RE: FedEx® Ground Facilities - Daytona Road NW
Town of Atrisco Grant, Unit 5, Portion of Tract 12, Tract 13 & Tract 14A
Erosion Sediment Control (ESC) Plan
Engineer's Stamp Date 5/19/2014 (K09-E026A)

Based upon your submittal received 5-20-14, the above referenced Erosion Sediment Control (ESC) plan is acceptable for Building Permit and Work Order based on the following conditions:

GRAVEL CURB INLET SEDIMENT FILTER (IPS)
N.T.S.

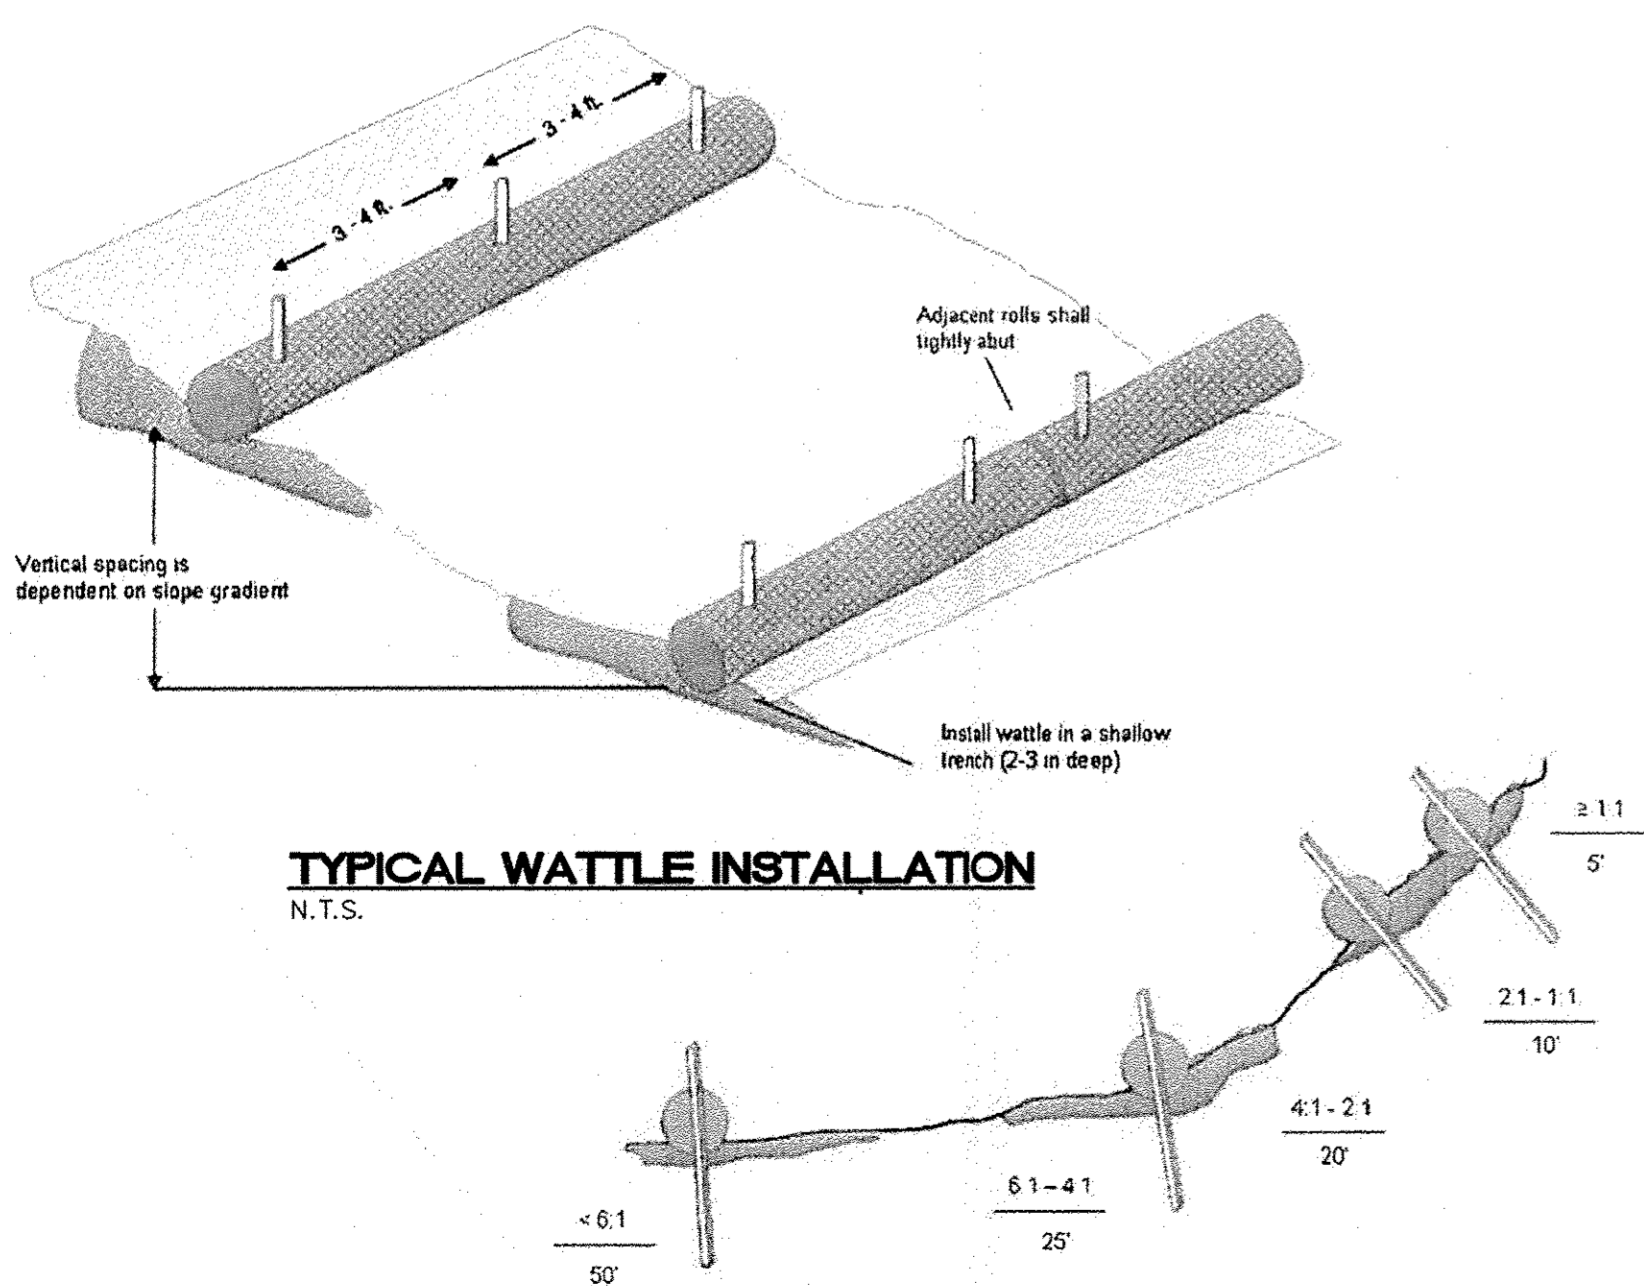
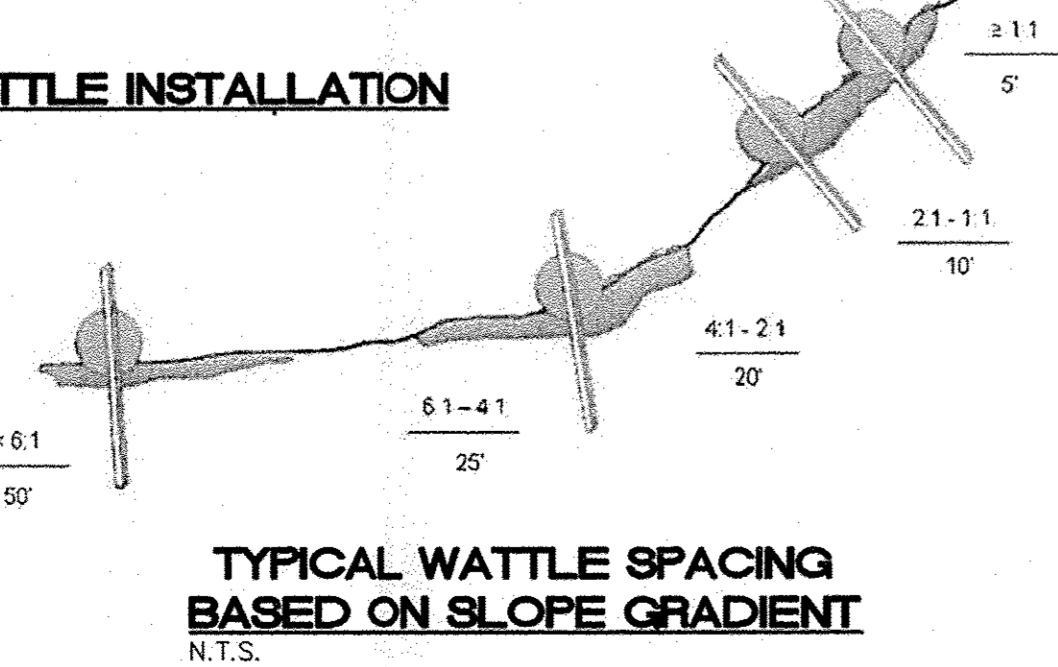
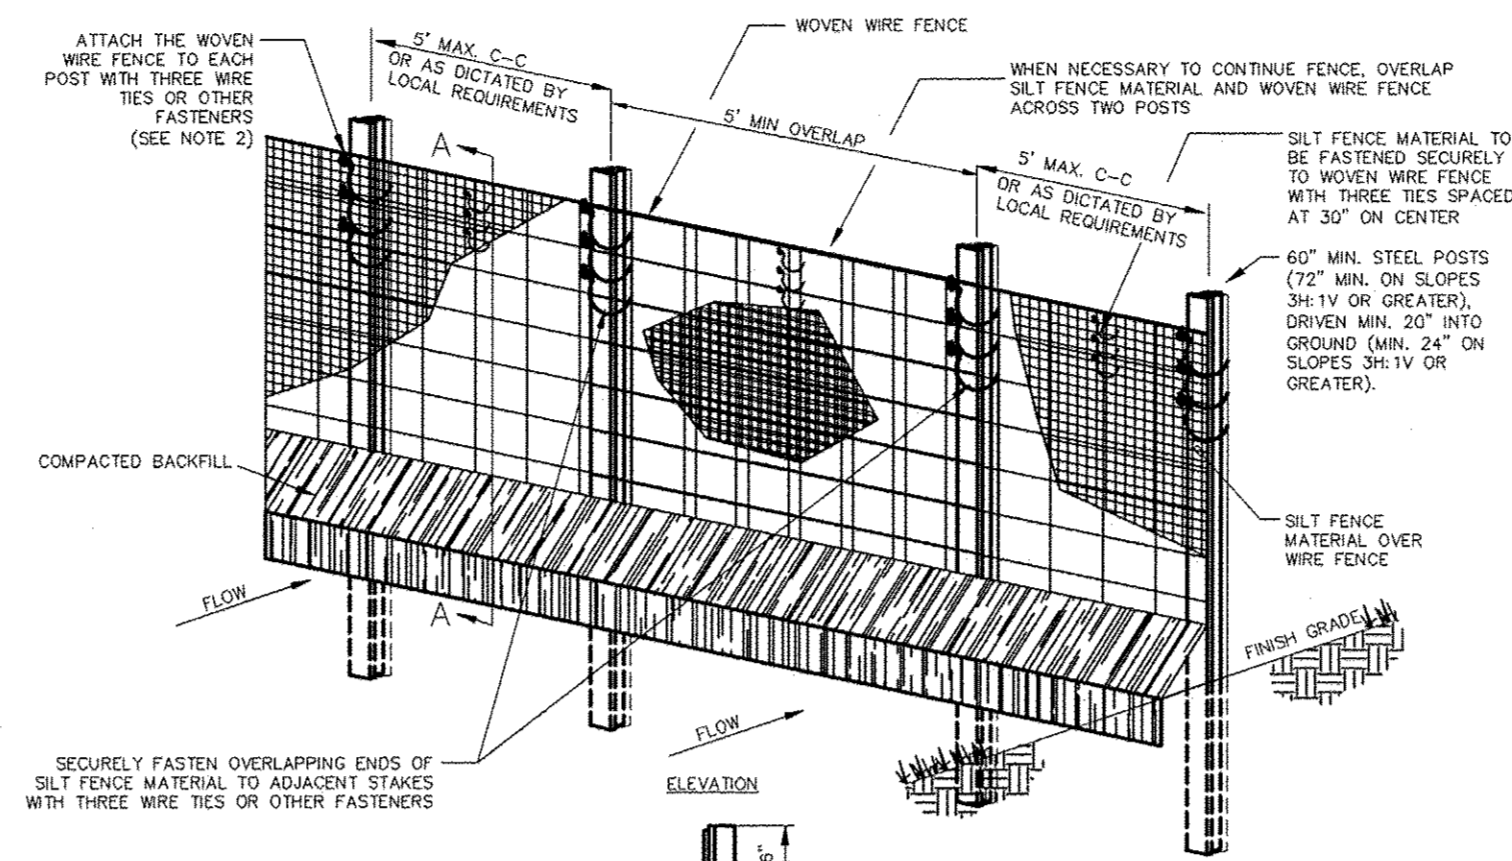
- 1) Inlet protection in Los Volcanos Road should be used only during the construction of the storm drain pipes within the right-of-way.
- 2) Please make sure that the proposed inlet protection in Los Volcanos Road will not cause flooding downstream of the project during monsoon.
